Inspector's Report ACP-321734-25

Whether the proposed extension and renovation of existing farm cottage is or is not development and is or is not exempted development.

Killeenavarra, Kinvara, Co. Galway

Whether renovation of an existing dwelling to include demolition of 37m² of domestic extensions to the rear of dwelling, demolition of water tank and shed (combined 10.48m²) to the side of dwelling, and construction of 40.3m² extension to the rear, comprises development which is exempt development?

1
-
GROUND FLOOR PLAN - PROPOSED
1:100

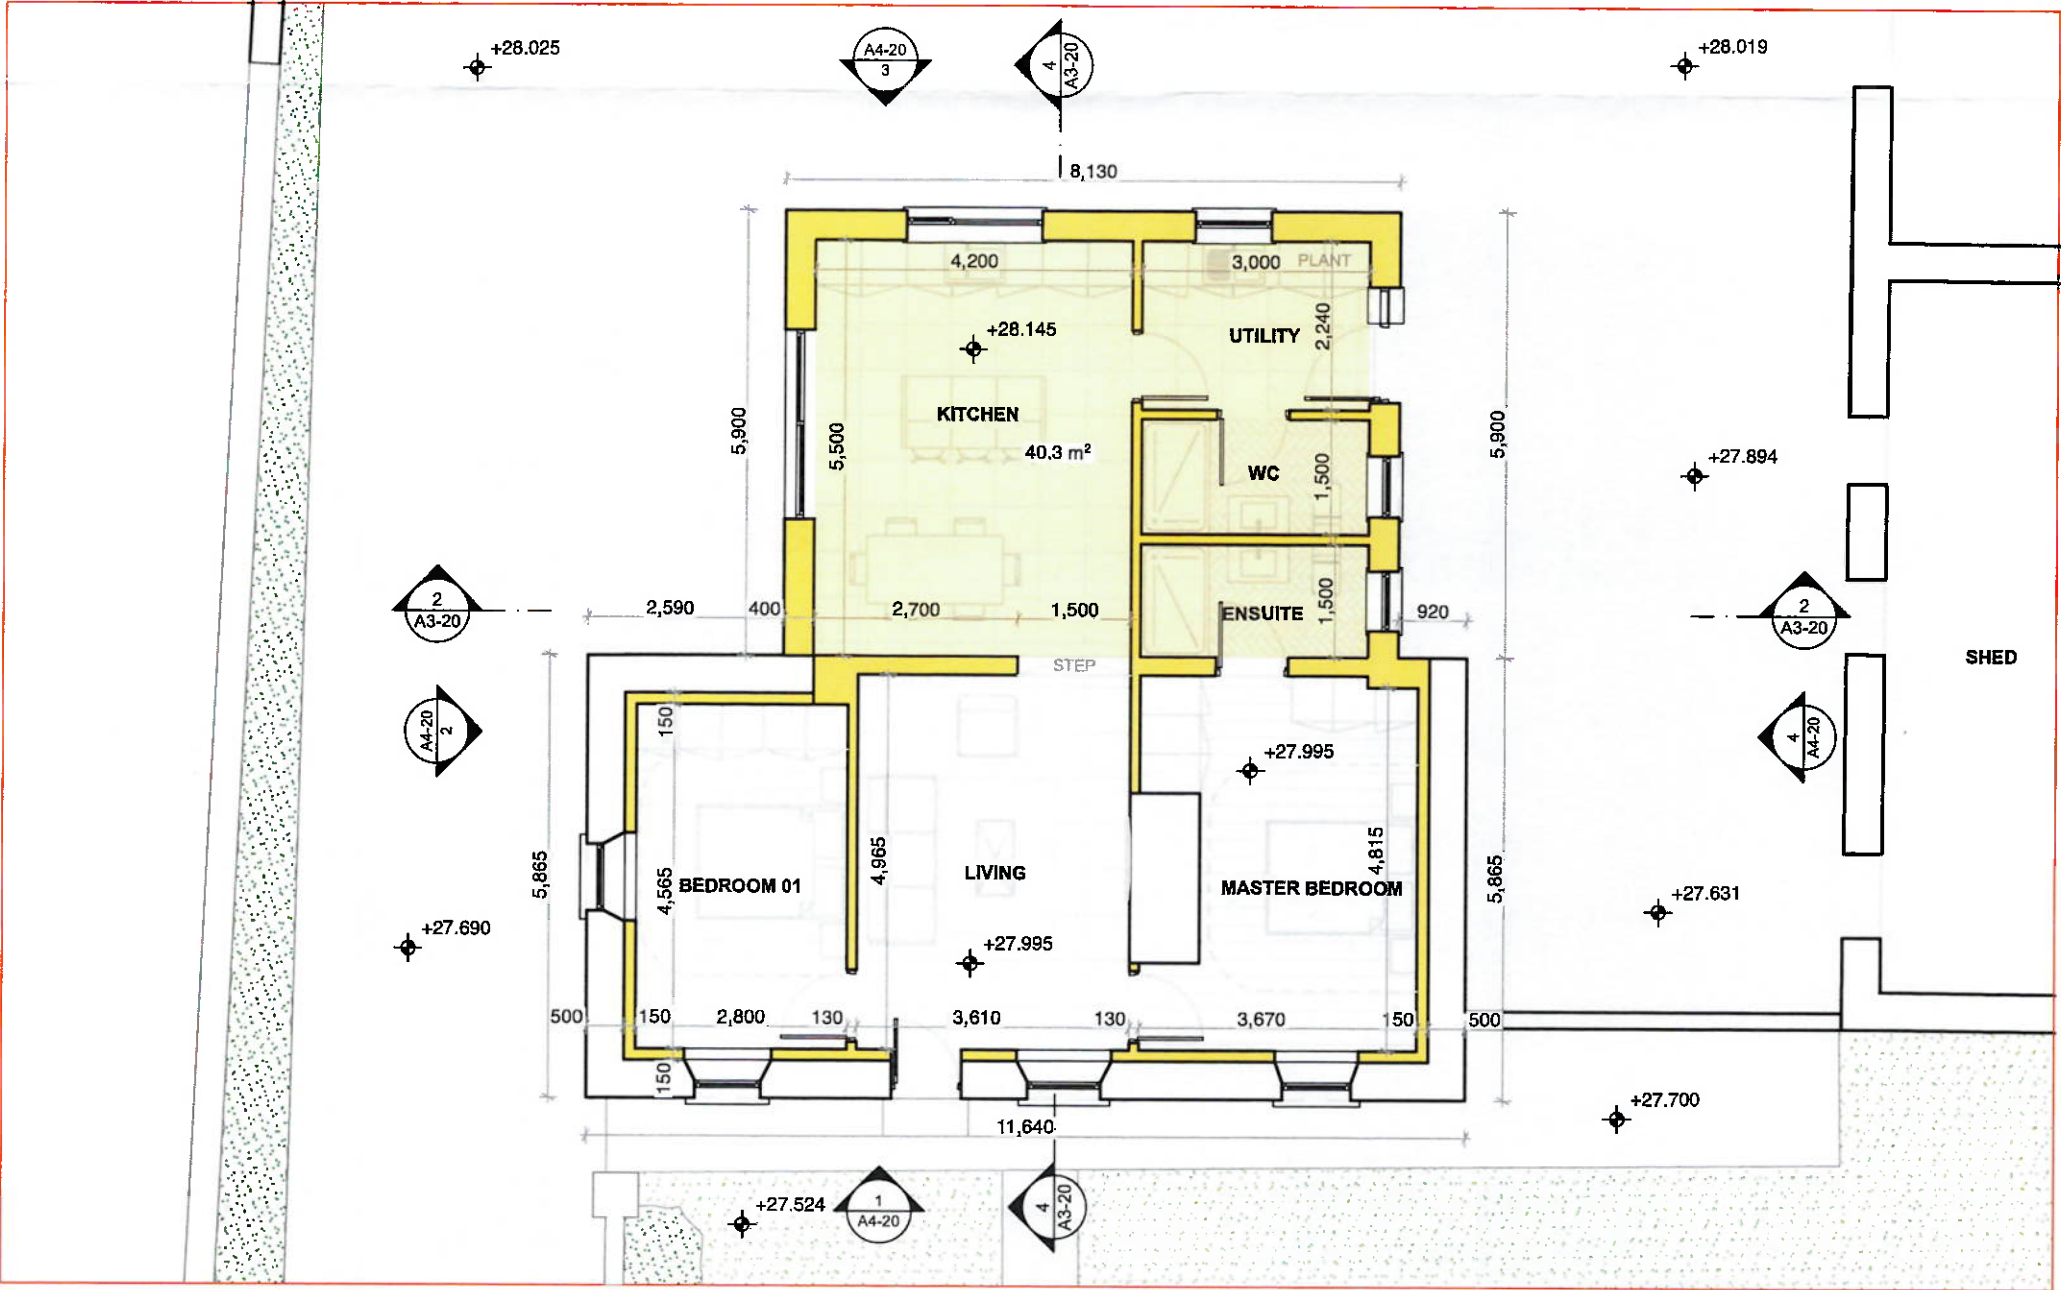
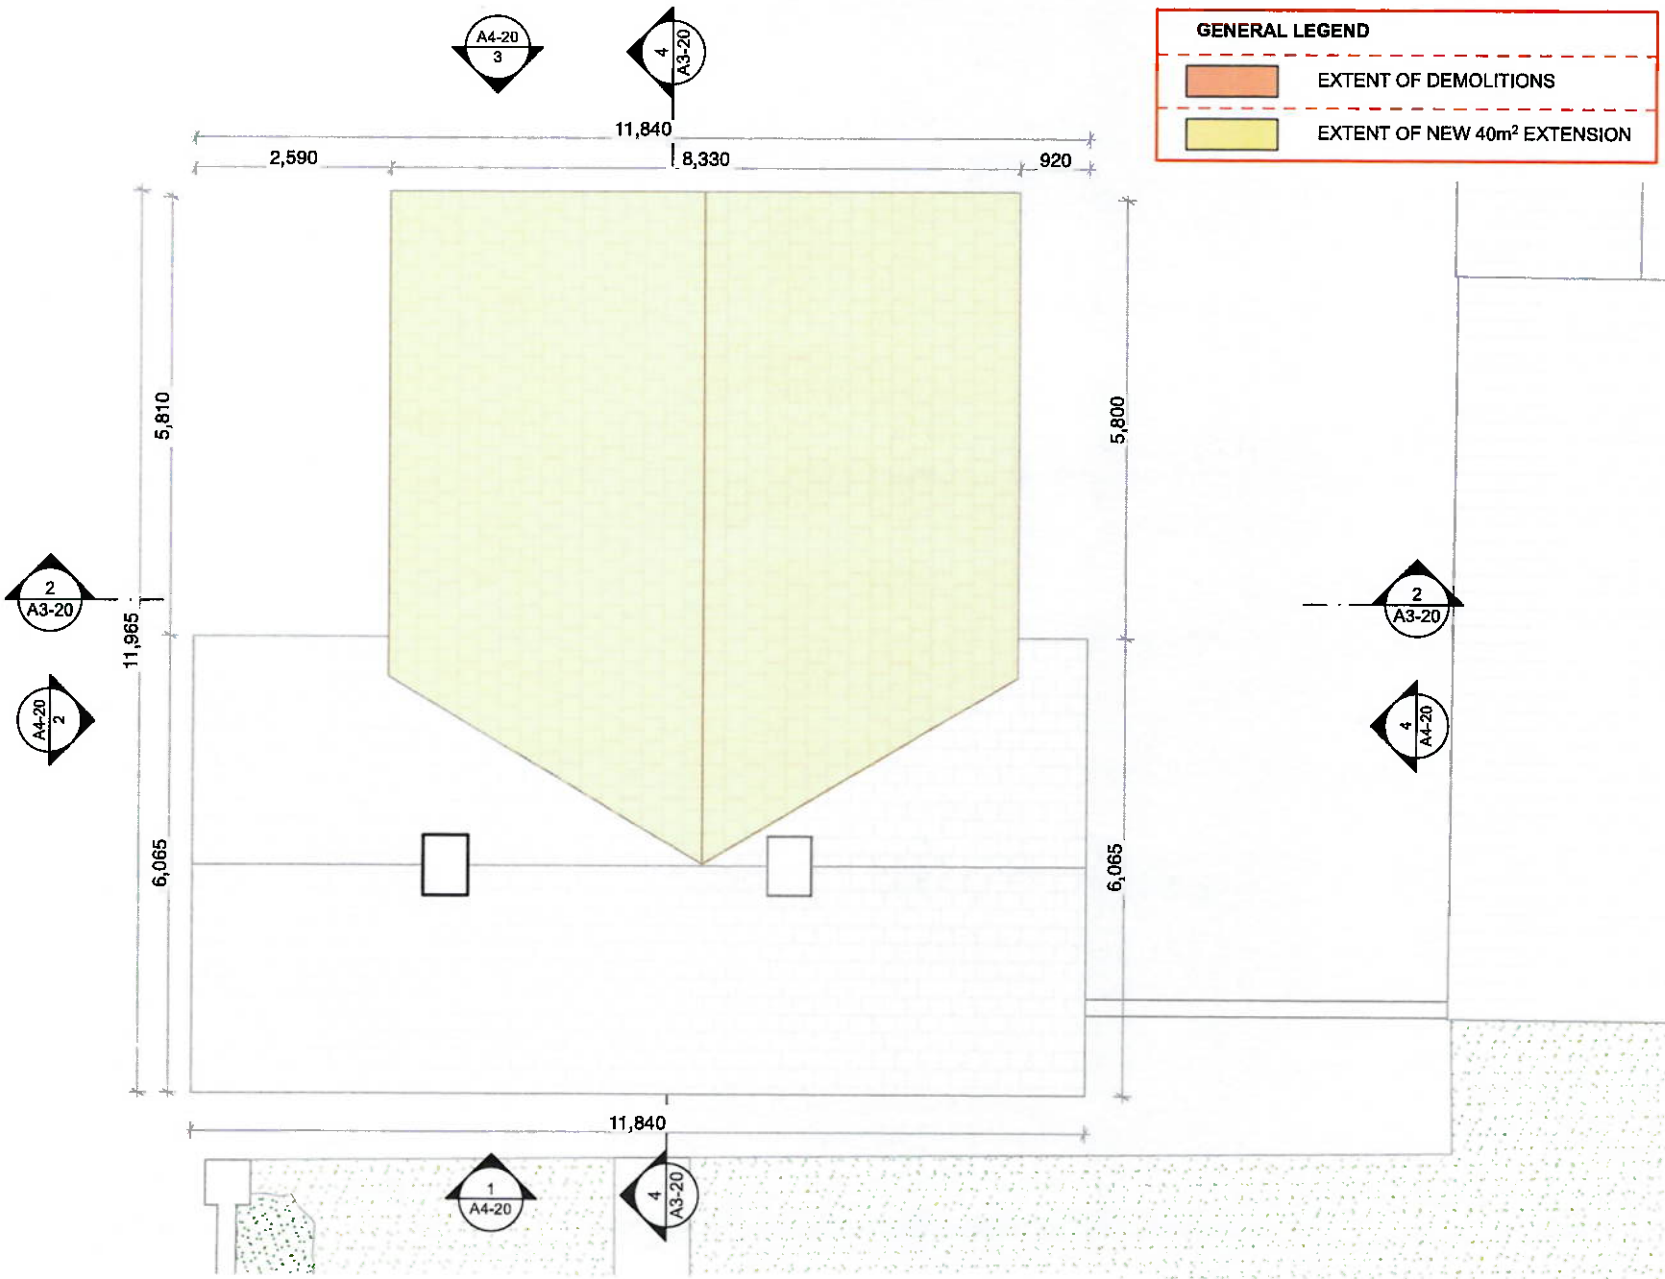
- 8.2.6. The proposed extension in this case, following demolition of the existing extension, would comprise 40.3m² which exceeds the limits in column 2. I note the referrer's case suggesting a condition is attached to reduce the floorplan within the permitted 40m² however there is no provision in the relevant legislation to facilitate this as this referral and exempt development declaration application is not a Section 34 planning application where such conditions can be attached.

- 8.2.7. The referrer also suggests that 'common sense' should prevail and the figure should be rounded to the nearest whole number, which would result in it being calculated as 40m² however once again there is no provision in the legislation for this.

- 8.2.8. Lastly, the referrer suggests that there would only be a net increase of 18.4m² overall when consideration is given to the floorspace provided in the existing extensions which, it is stated, were constructed prior to 1963. No definite evidence has been submitted to support this however it is an immaterial consideration as the previous

8.2.9. In this regard, the proposed development does not fully comply with the provisions of Class 1 and therefore is not exempted development. Further, as the extension does not comply with the provisions of Class 1 it therefore leads to the conclusion that proposed demolition of the existing extensions are also not exempt development as the demolition is not connected with development which accords with Class 1.

- (e) The proposed extension comes within the scope of Class 1 of Part 1 of Schedule 2 to the Planning and Development Regulations 2001 but does not meet the conditions and limits set out in Column 2 as it would exceed 40m² floorspace;

(b) demolition of 37m² of domestic extensions to the rear of dwelling, demolition of water tank and shed (combined 10.48m²) to the side of dwelling rear and construction of 40.3m² extension to the rear is development and is not exempted development.

FLOOR PLANS - EXISTING

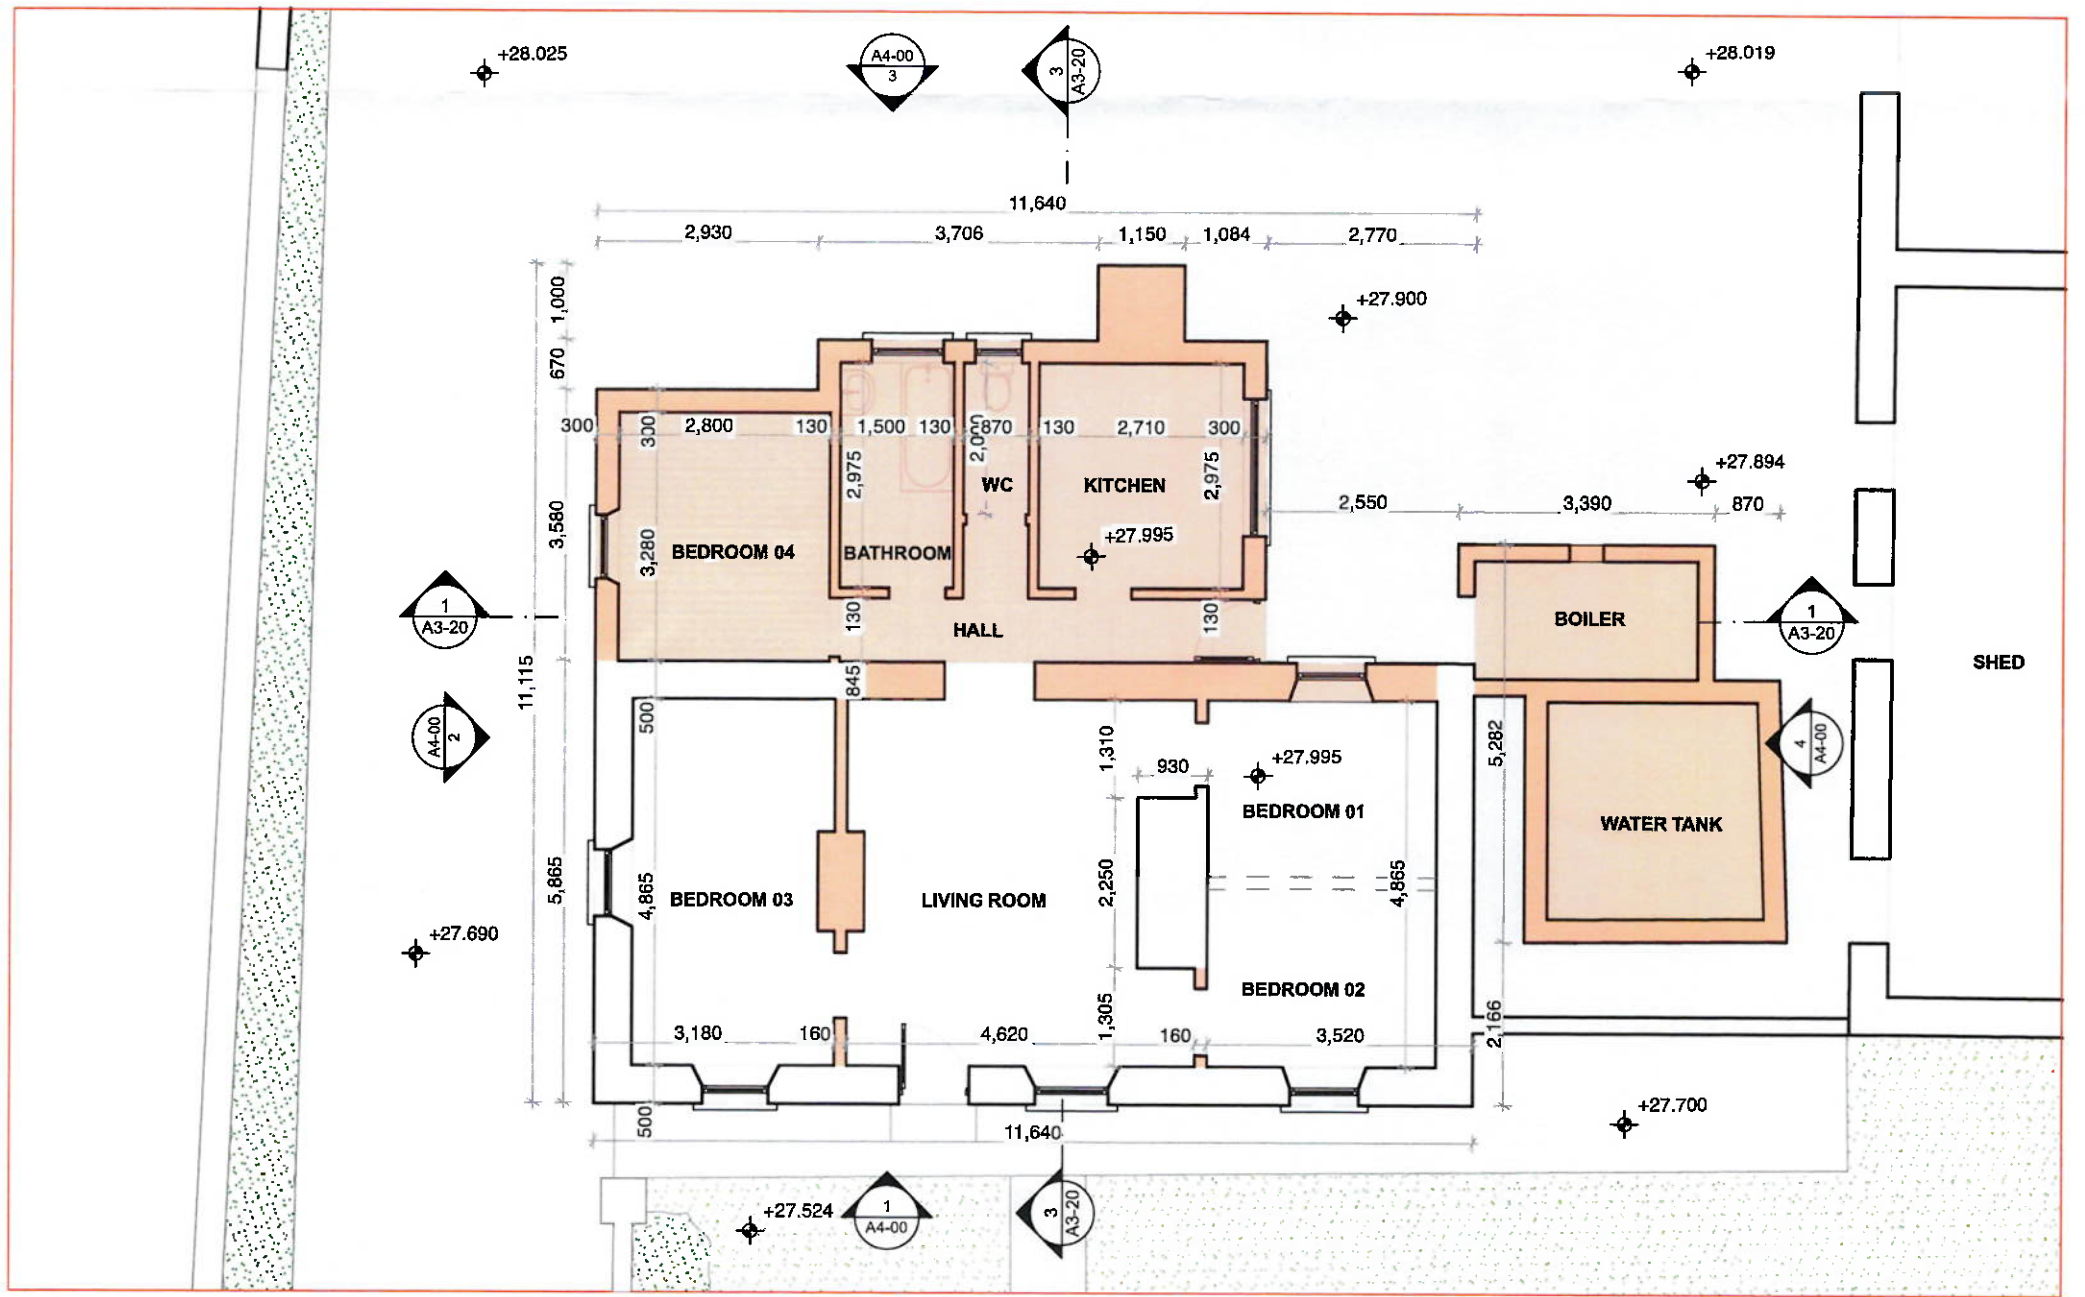
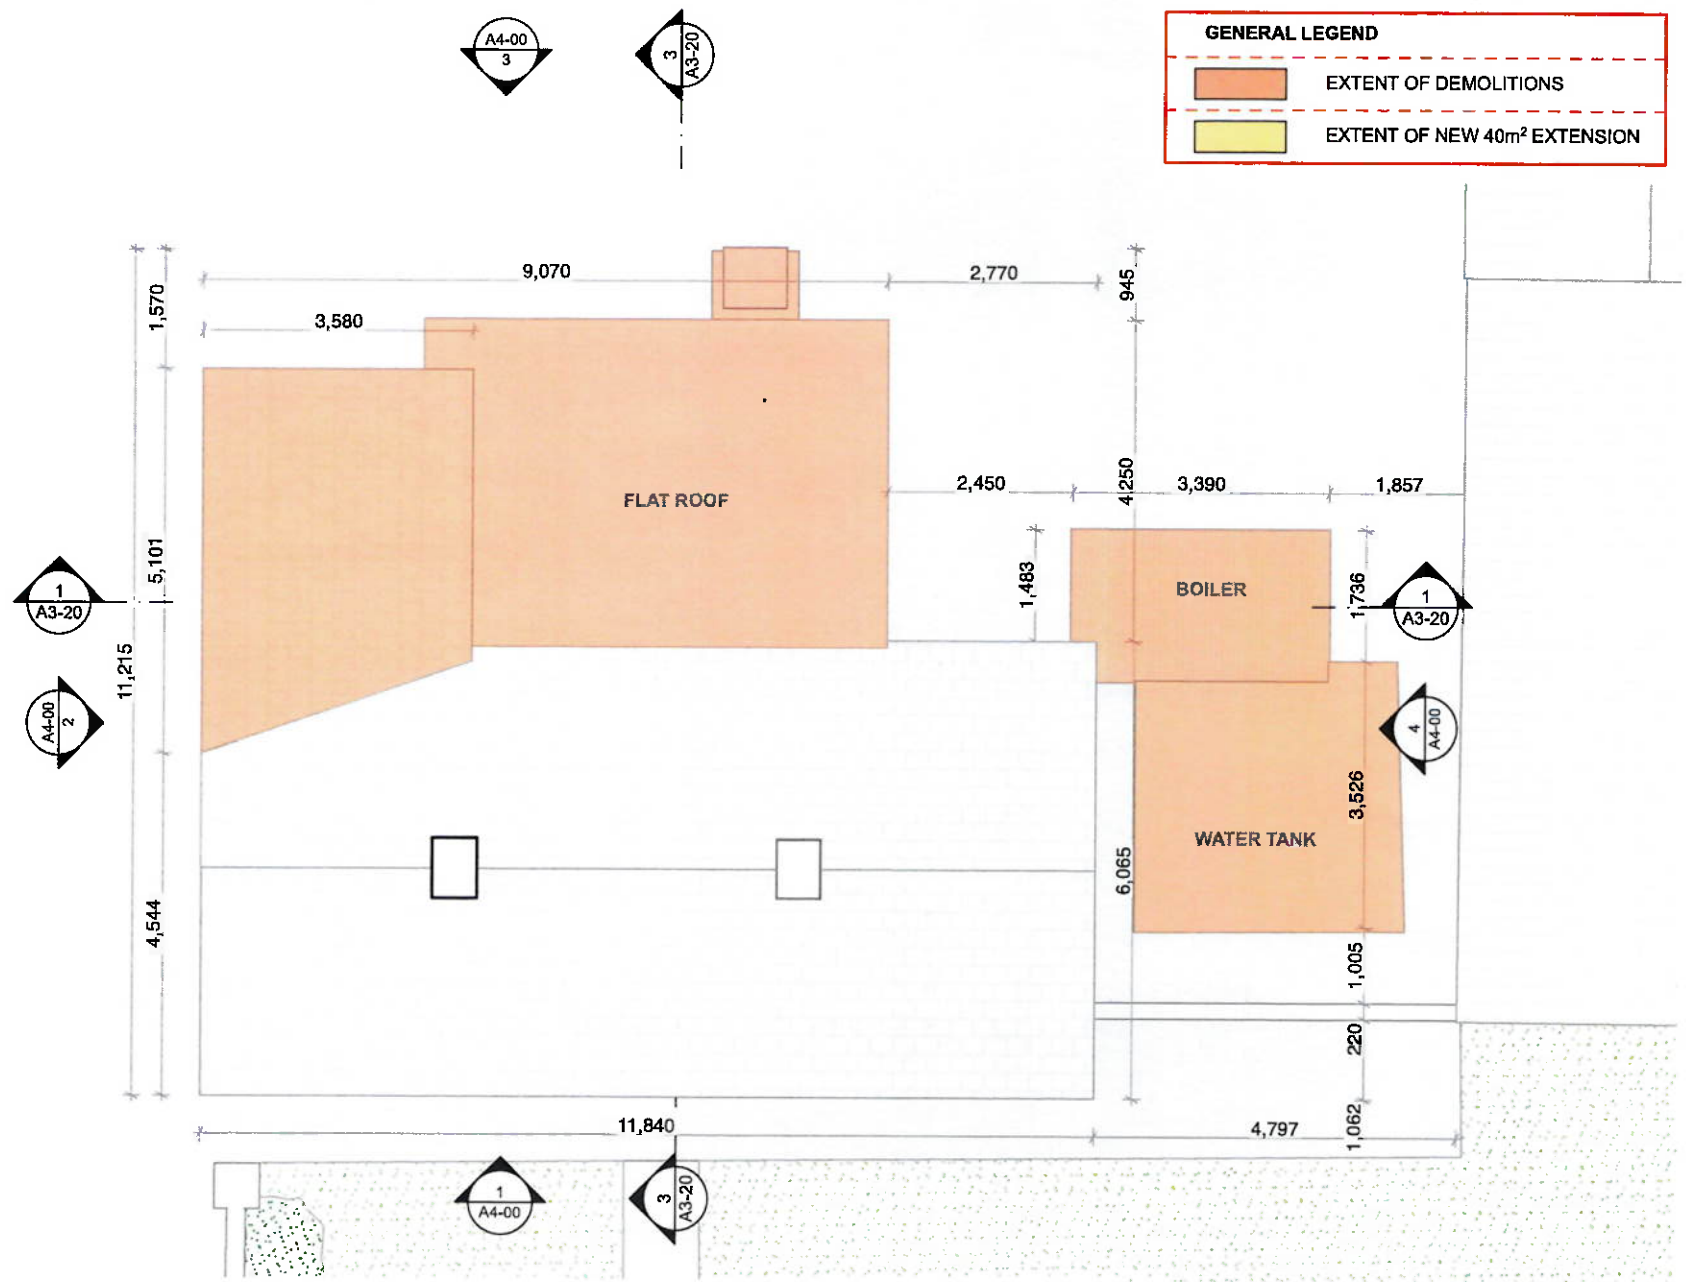
extension would ultimately cease to exist following its demolition as proposed, and therefore any new extension would constitute a 'blank slate' with the 40m² threshold applying. I refer the board in this case to the precedent cases set out above where the same analogy was applied and conclusions drawn.

- (f) Demolition of the existing domestic extensions does not come within the scope of Class 50(b) of Part 1 of Schedule 2 to the Planning and
